CITY OF ALBUQUERQUE

**Re: Casa de Oro Townhomes Grading and Drainage Plan, 921 & 923
Montano**

Engineer's Stamp Date 05-15-2013 (F-14/D068)

ENGINEER'S SEAL	Casas de Oro Townhomes 921 & 923 Montano Rd.	DRAWN BY WCW/J
		GRADING AND DRAINAGE PLAN	DATE 4-19-13
		 <i>Rio Grande</i> Engineering 1606 CENTRAL AVENUE SUITE 201 ALBUQUERQUE, NM 87106 (505) 872-0989	21319-LAYOUT-4-16-13
DAVID SOULE P.E. #14522			SHEET # —
			JOB # 21319

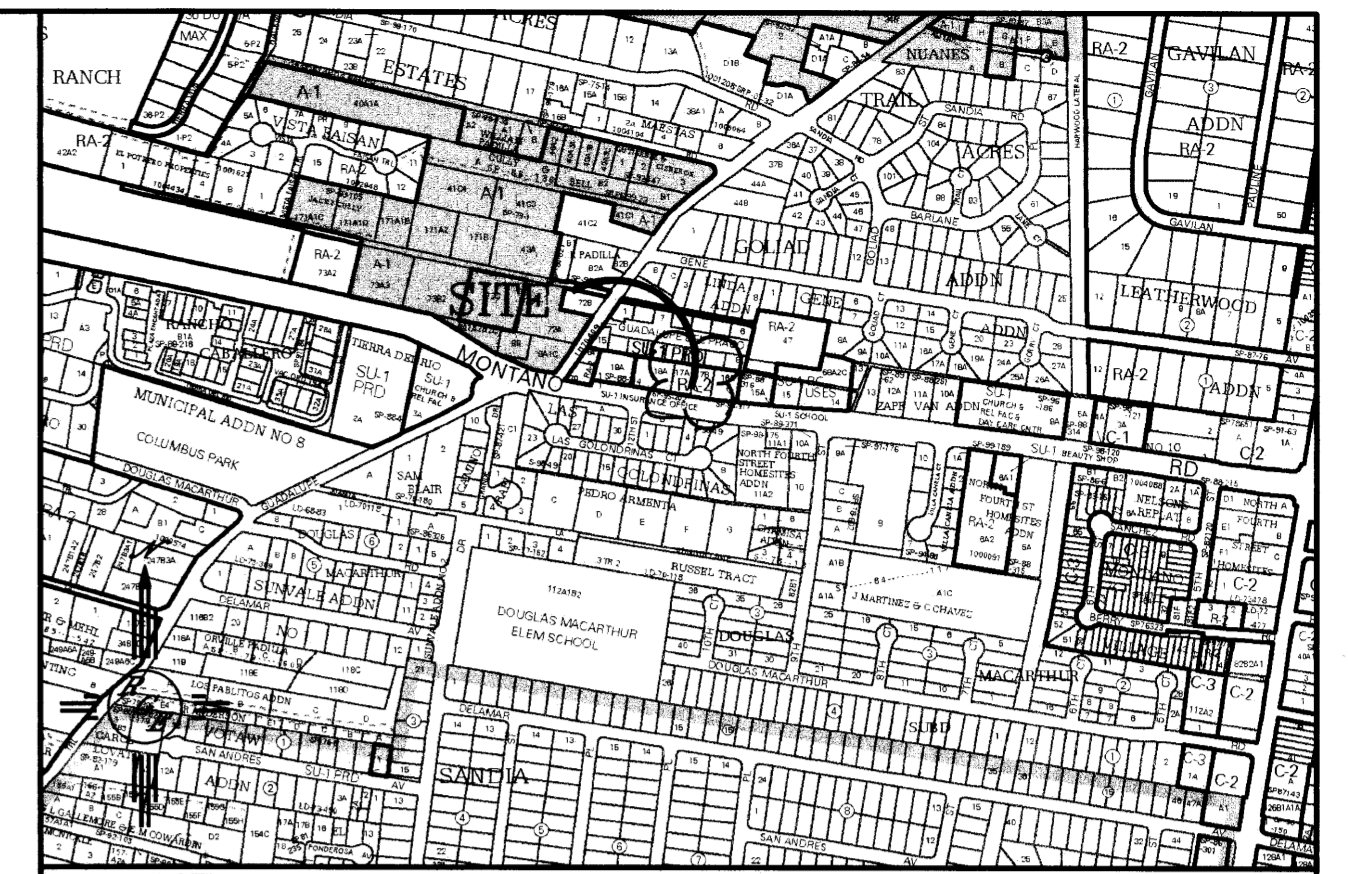
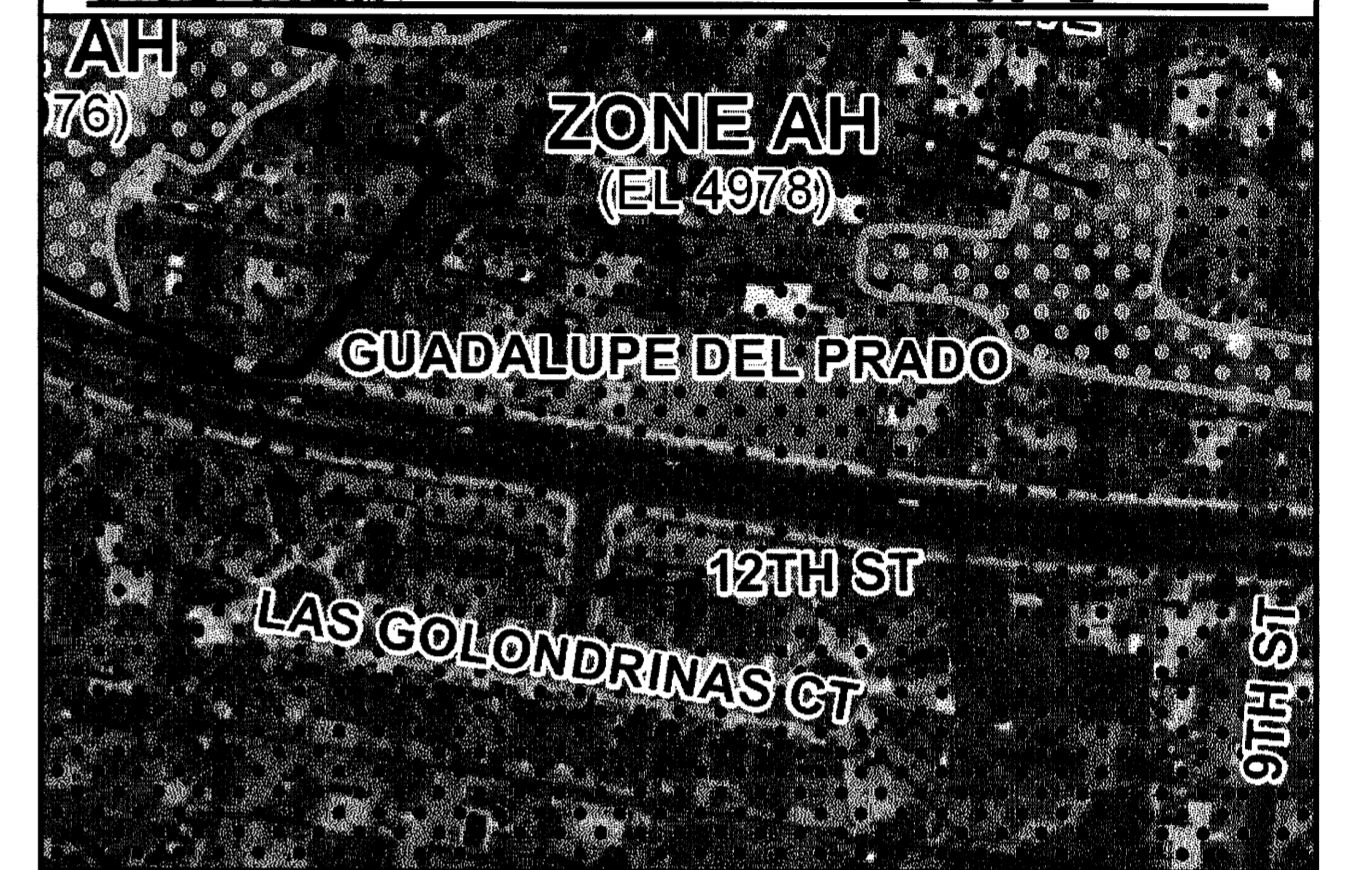
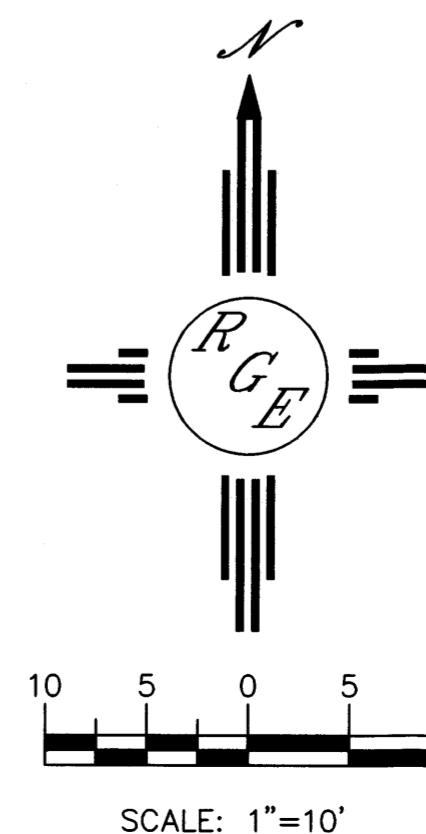
- Please provide back-of-sidewalk elevations on the grading plan.
- It appears that flows from the centrally located retention ponds might back up against the adjacent lot to the north.
- The plan shows two finished floor elevations for each of the building pads; please correct to show one finished floor and one finished pad.

1. Provide back of sidewalk elevations
These spots have been added
2. It appears the flow from central ponds will back up against lot to north
We have added spots to demonstrate the ponds will spill to driveway then to Montano.
3. The plan has two finished floors
We have corrected the spelling error, and have finished floor and pad
